CTC AND SPLS RESPONSE TO ISSUE SPECIFIC HEARING 2 DEALING WITH ENVIRONMENTAL MATTERS

Technical Note 3;

**“9.18 ExA.CWR.D3.V1 – Appendix 2 to Applicant’s
responses to Written Representations
submitted at Deadline 2”**

2.47 - Ashton Vale Road and Winterstoke Road Highway Works Plan

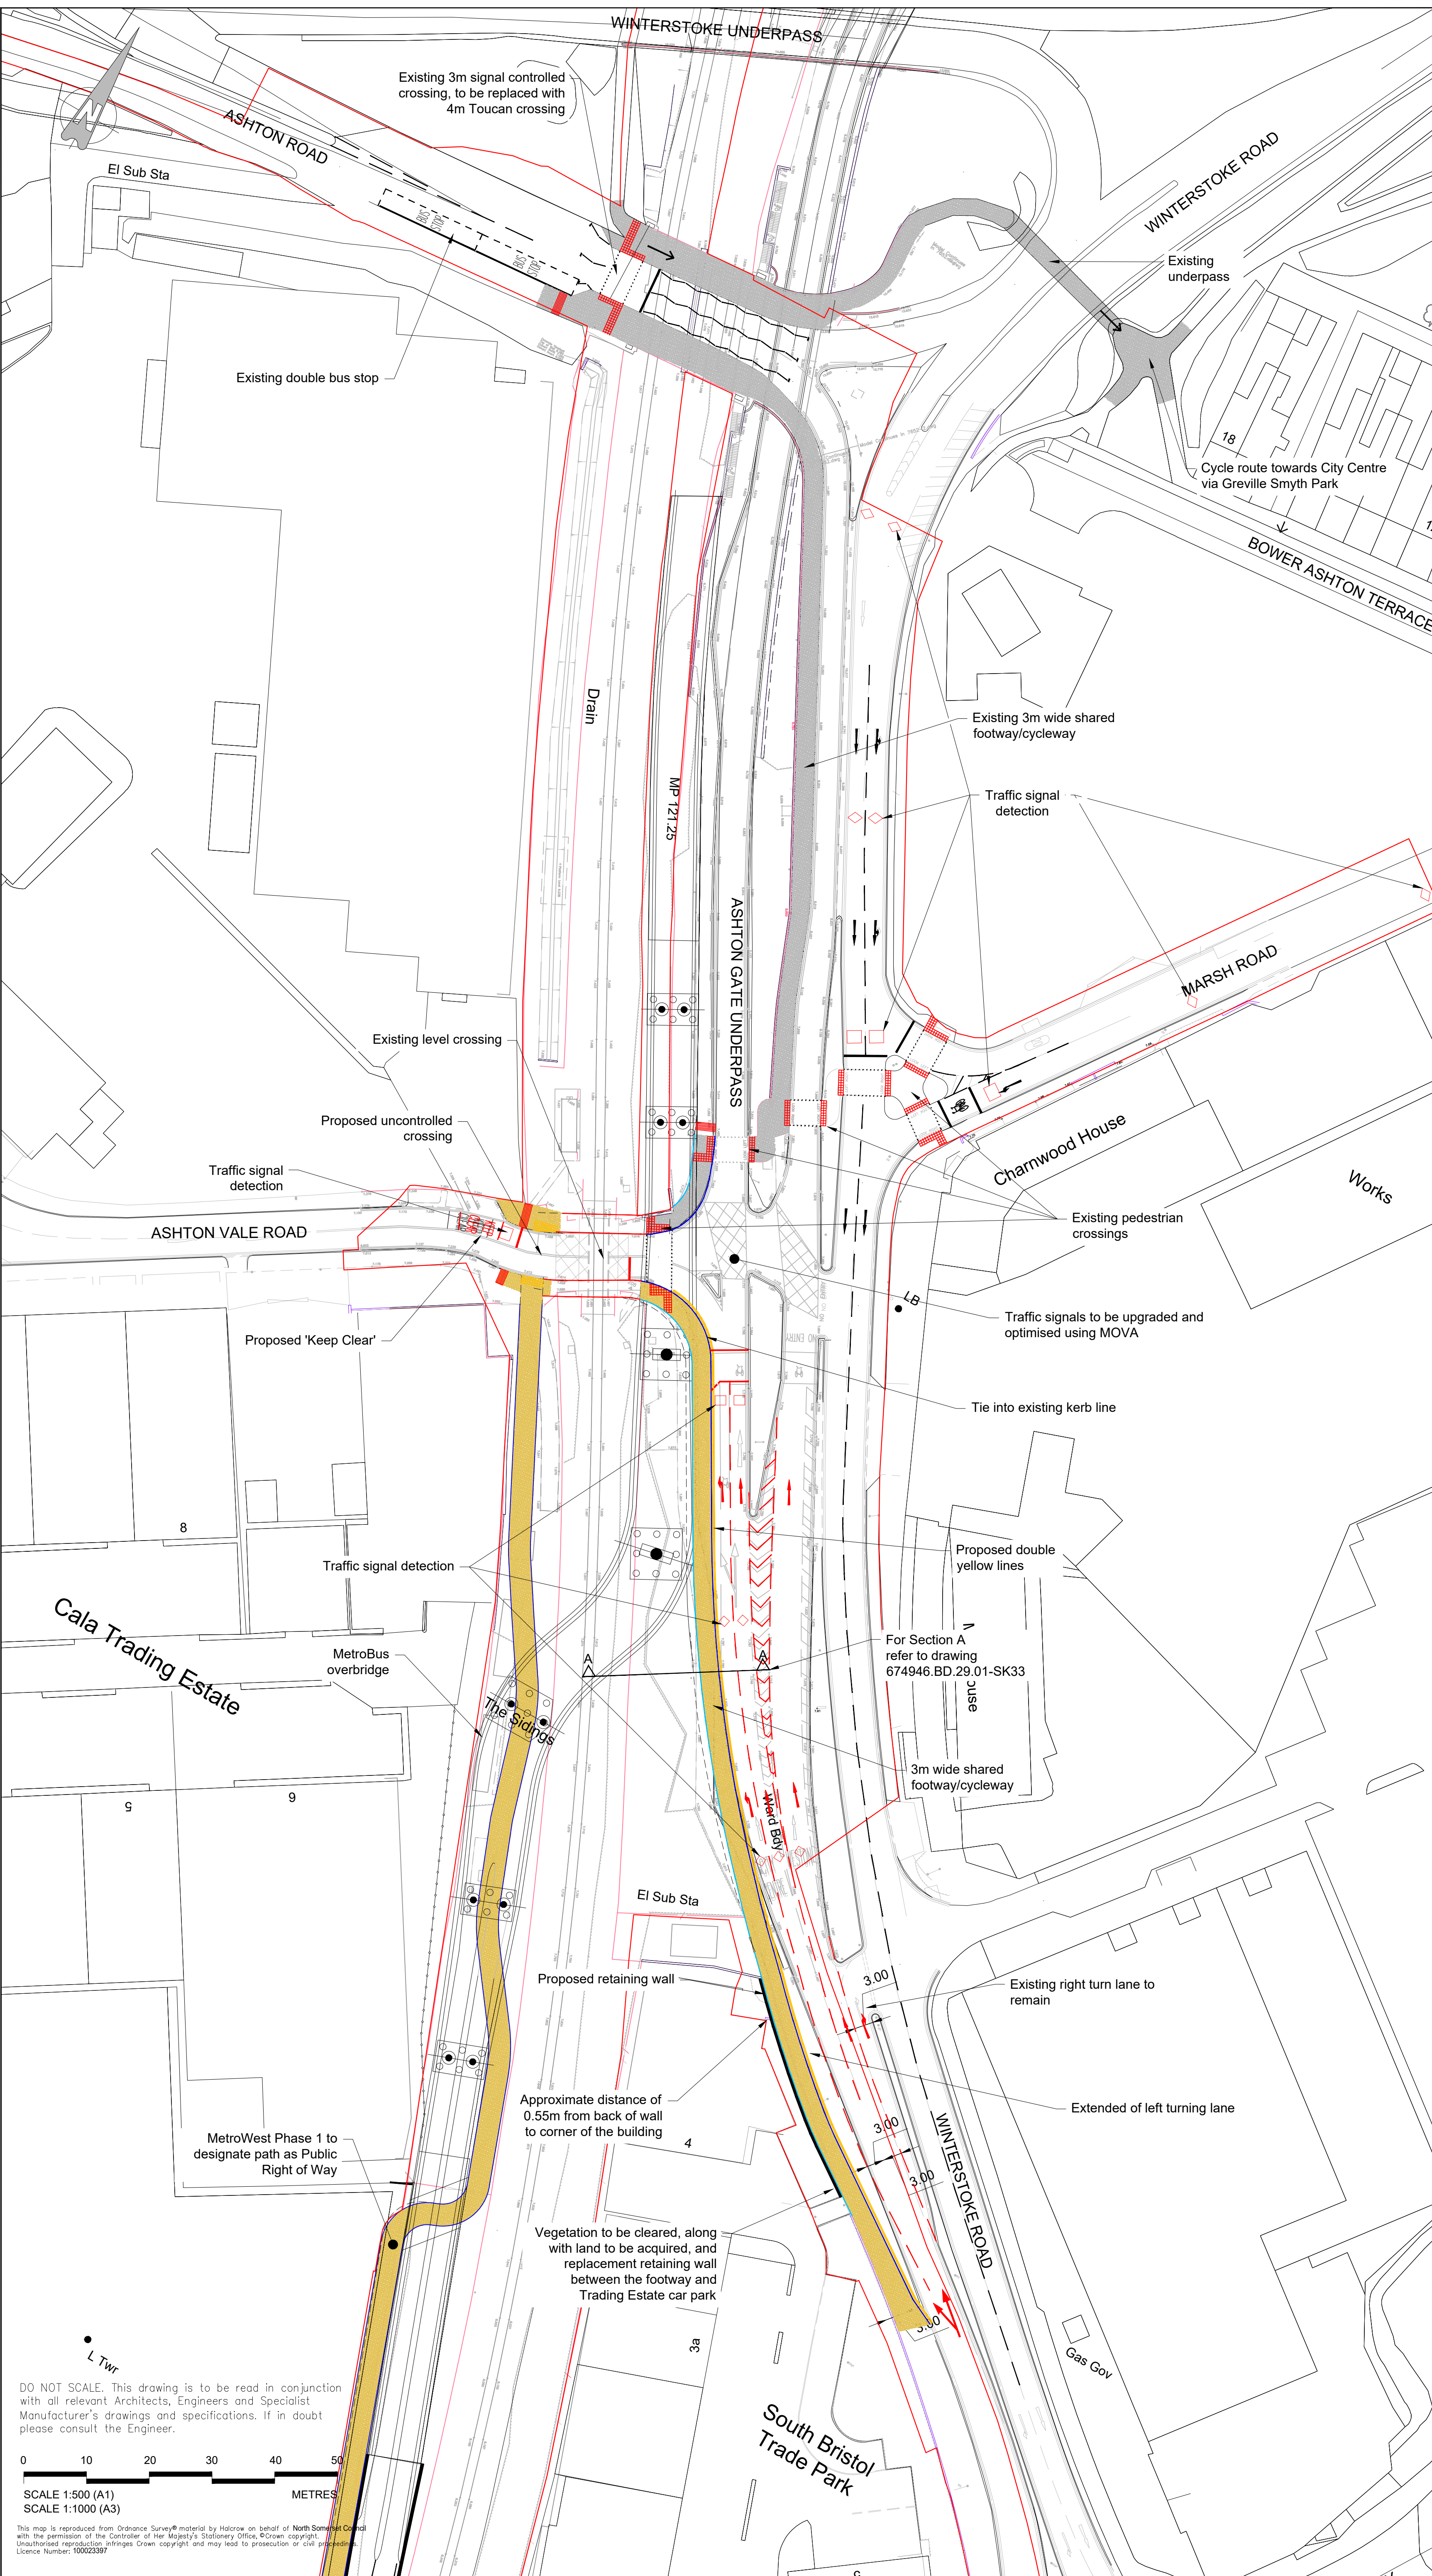
- 2.8 cTc identified and Jacobs acknowledge that a northbound left turn lane into the Ashton Vale Industrial Estate was closed at the time of their surveys and this was initially dismissed on the basis that the enumerators considered it had no impact on traffic flows or junction usage. Key questions arise here;

- How are the enumerators qualified to make this judgement?
- 2.9 cTc finds it more than simply surprising that Jacobs continue to claim that these road works were of no impact. At Photograph 1, below is an image extracted from Google Streetview at April 2017; broadly the time of the surveys on which the VISSIM and Linsig models have relied. It is unconscionable that roadworks on this scale, requiring left turning Ashton Vale traffic to share a lane with ahead traffic, towards Long Ashton could not have impacted upon the convenience of accessibility of Ashton Vale Industrial Estate. This therefore adds significant doubt as to the reliability of traffic survey data, either counts or journey times, collected during these roadworks.

- 2.20 In order to 'address' the above issue, Jacobs has constructed a model with the dedicated left turn lane (Winterstoke Road to Ashton Vale Road) closed, calibrated and validated this, then subsequently adjusted to reflect the normal situation; with a dedicated left turn lane and an ahead lane. This manual adjustment clearly acknowledges that, contrary to Jacobs' assurance discussed above, traffic characteristics during the surveys were not normal and the matter has sought to be addressed by manual adjustment of the model, subsequent to validation against an abnormal dataset. cTc maintains that that is a wholly inappropriate approach, which has resulted in a model on which no reliance can be placed. That TAG M1.2 places such emphasis on ensuring collection of traffic data from neutral periods confirms the importance of this issue.
